**Wambo Coal Mine South Bates Extension (DA 305-7-2003 MOD 17)
Comment on the Environmental Assessment (EA)**

Wambo Coal Mine South Bates Extension (DA 305-7-2003 MOD 17) Request for Input into Secretary's Environment Assessment Requirements Detailed comments

Figure 24 P114 Calibration Hydrograph

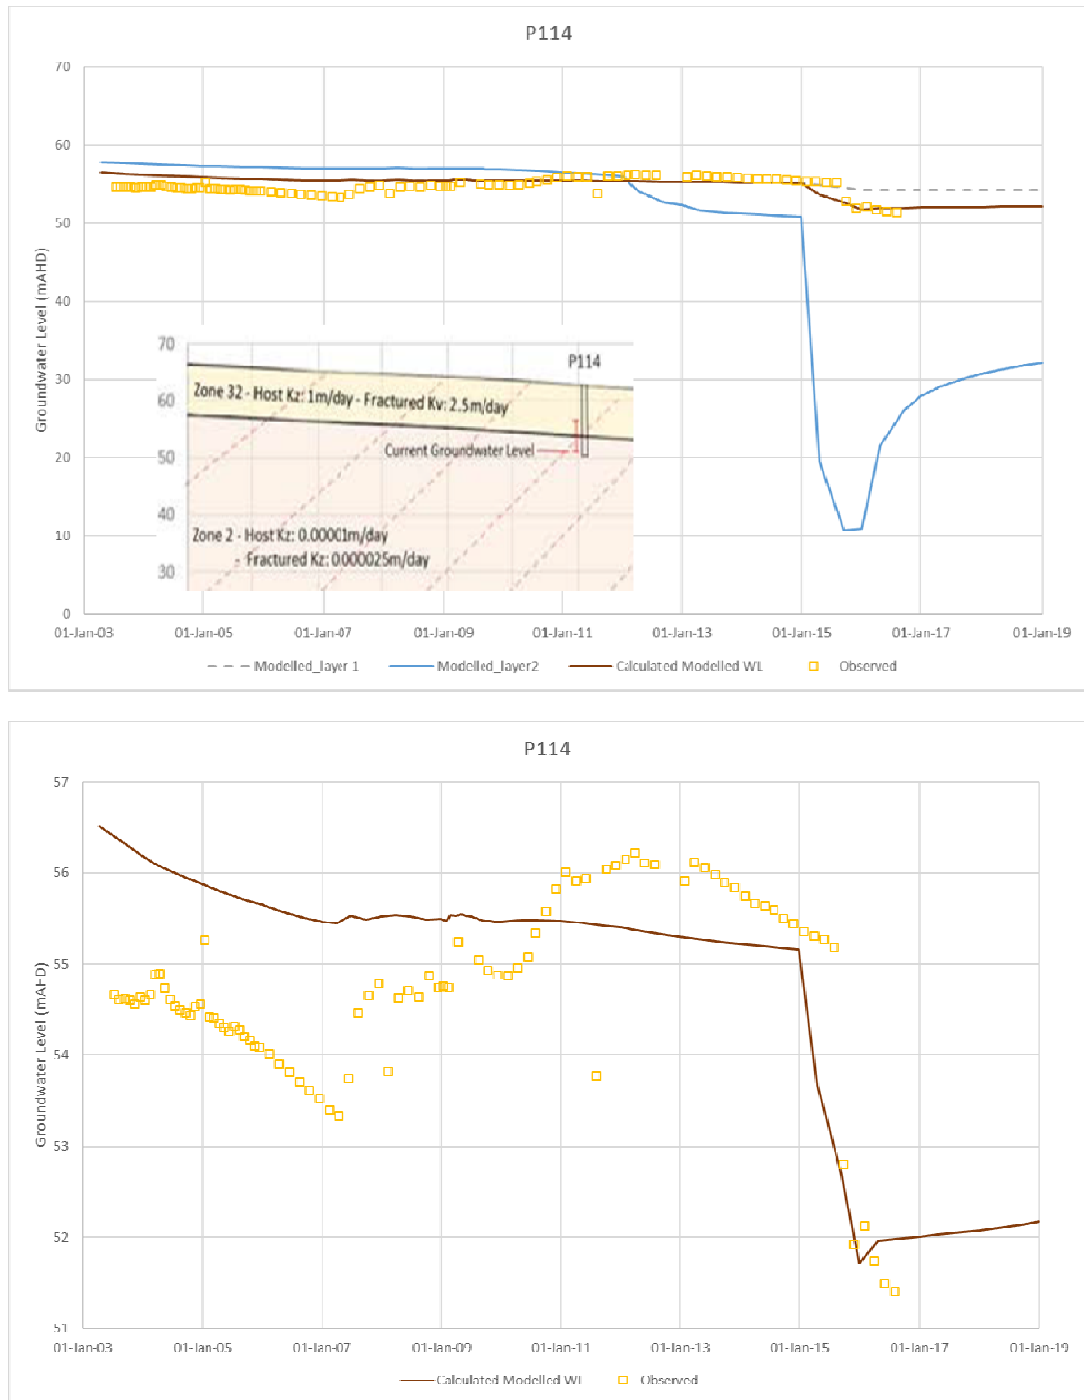
- Similarly in relation to section 3.8 of the Hydrosimulations report regarding model calibration it is noted that P114 is located outside the revised extent of alluvium as per the TEM survey by Groundwater Imaging (2012). DPI Water has not yet determined the accuracy of this revision of the alluvial extent and as per the comments made during the Response to Submissions stage of modification 12 it is recommended that further drilling occurs with all lithology logs to be submitted to DPI Water for review. This is important to increase understanding of the target aquifers being monitored and increase confidence in the model outputs.
